Application No. LV/5/11

**RE: Kite surfing centre. The Promenade, Sea Road, Littlehampton.**

**SUBJECT: LU/5/11- Conversion of shelter to kite surfing centre (D2) including cafe facilities  
(Revision of LU/173/10).**

**Seating Shelter, The Promenade, Sea Road, Littlehampton, West Sussex**

ARUN DISTRICT COUNCIL	
No.	20 5 11
SUBSTITUTION	
Received	26. 1. 11

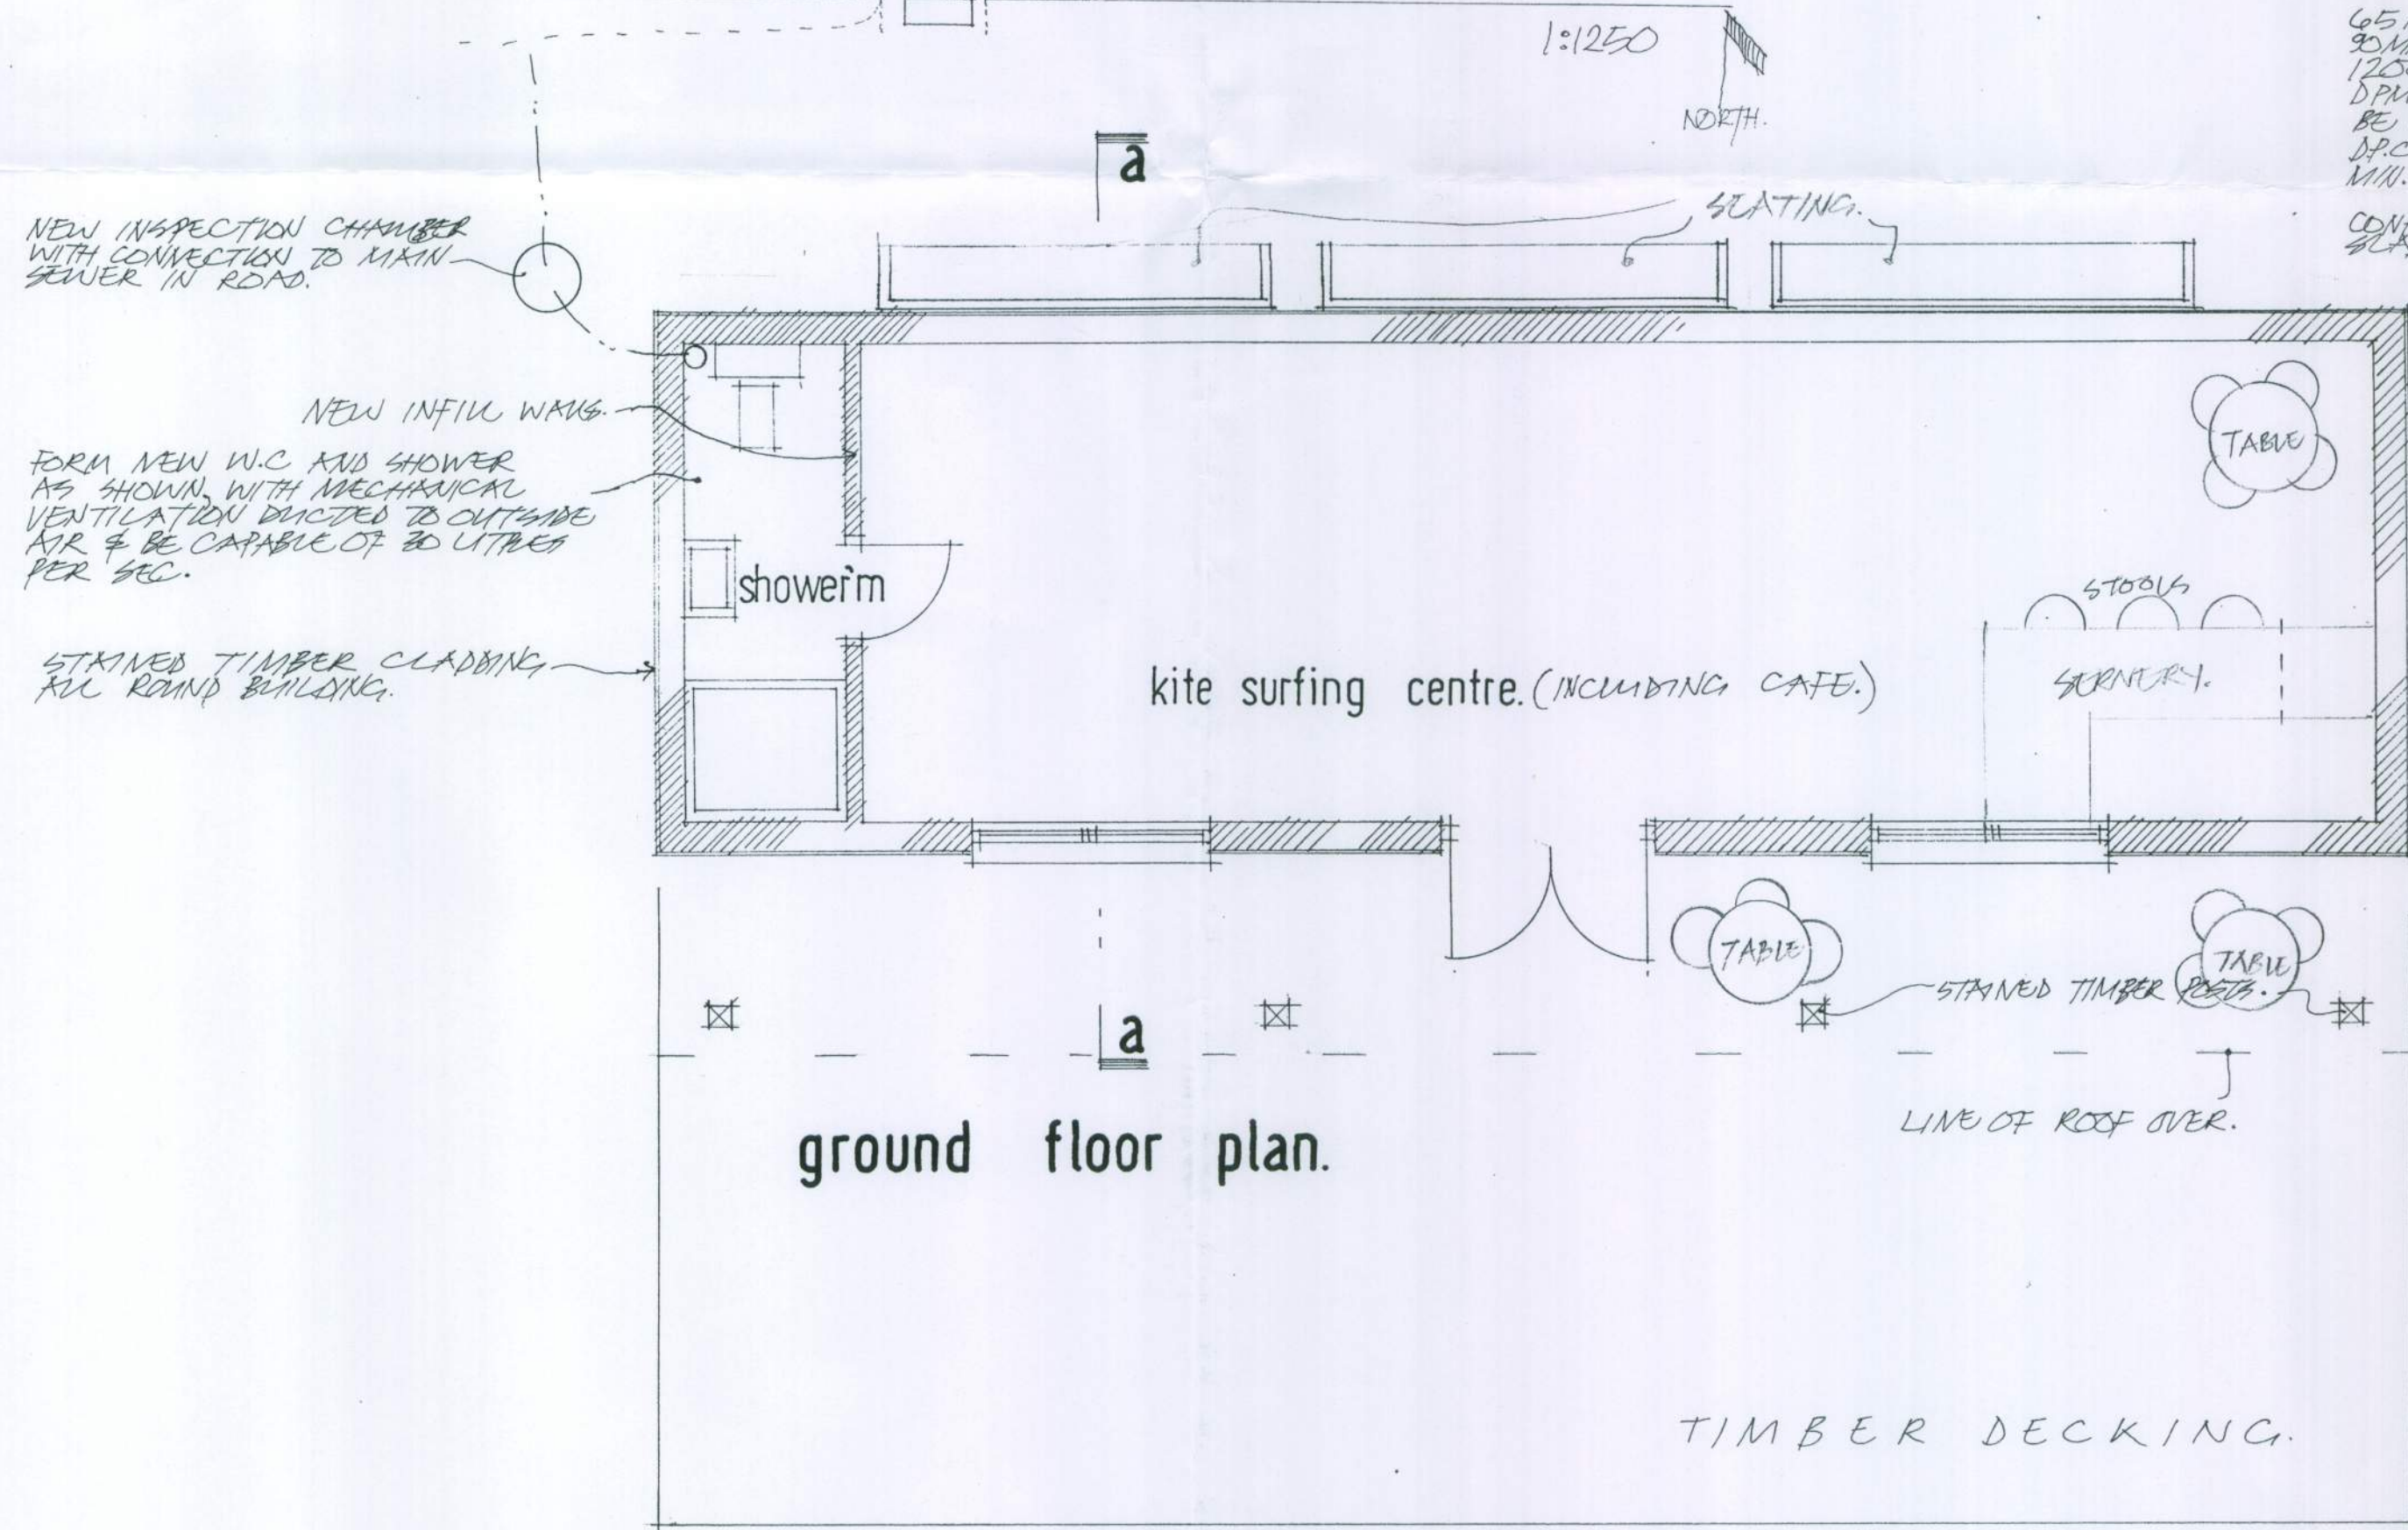
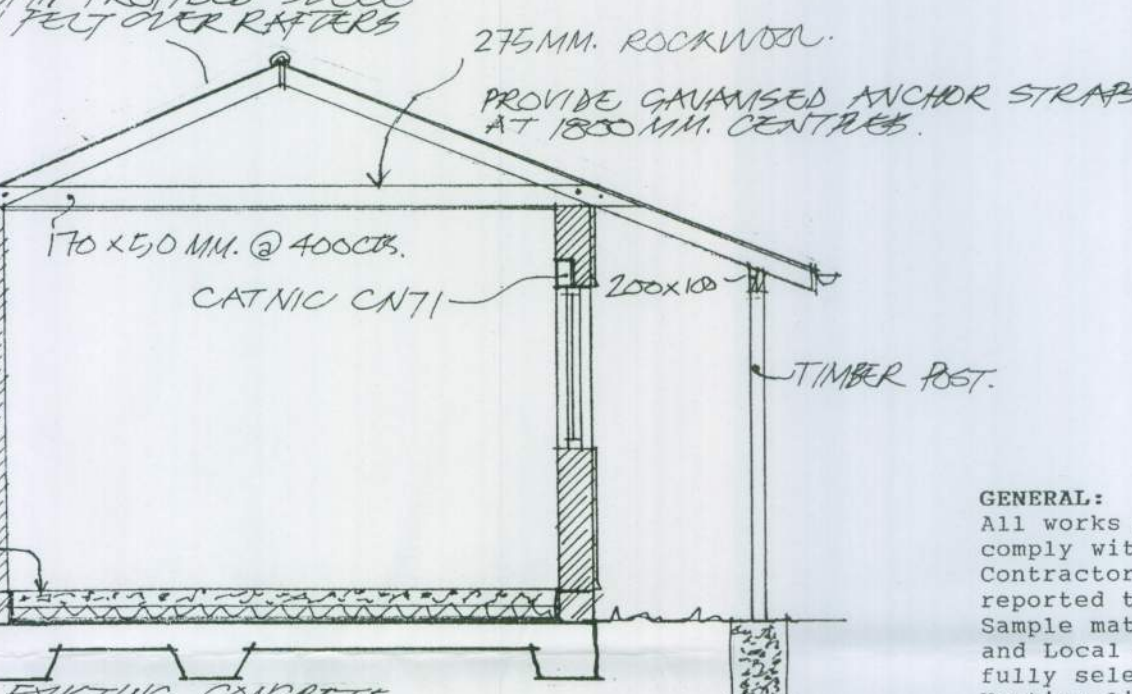
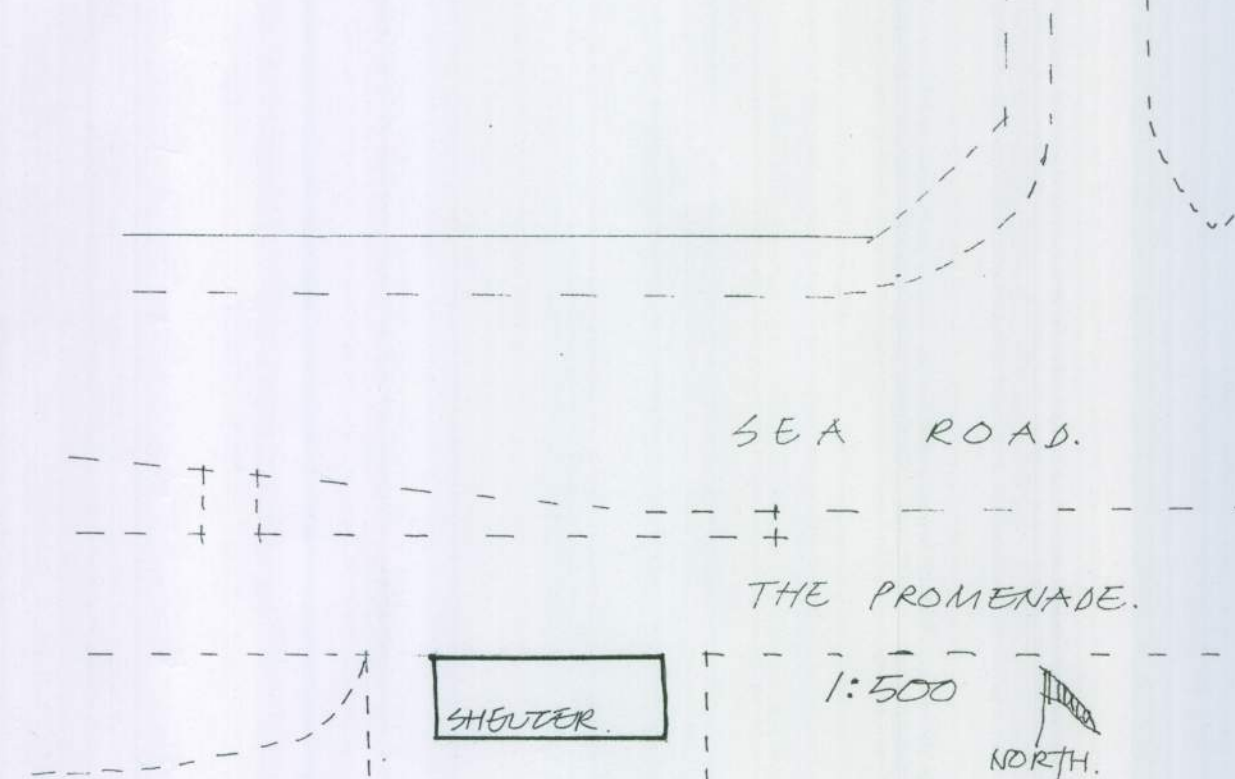
Objection from EH Food Team. The accompanying drawings submitted with the application documents do not illustrate how these premises will achieve compliance with current food hygiene legislation or provision of adequate sanitary accommodation for customers consuming food and drink on the premises, if 'cafe facilities' are provided for commercial hot & cold food activities. If however, the proposal is confined to providing retail sales of soft drinks, and to provide a leisure/club facility for kite surfers, lesser requirements would apply and be achievable. The term 'Cafe Facilities' implies a wider use of these premises, which determines a higher level of control and requirements.

Please submit amended floor plans showing the proposed cafe area. The design & access statement does not refer to the cafe, please submit an amended statement accordingly

*With regard to the above application I enclose my revised drawing showing the toilet separated from the shower as discussed with your colleague and trust this will enable the application to be approved.*

With regard to the above application I enclose revised design and Access Statement and floor plans showing café and seating area.

Please note it is not intended to have a café / restaurant but café/ teas/ snacks.
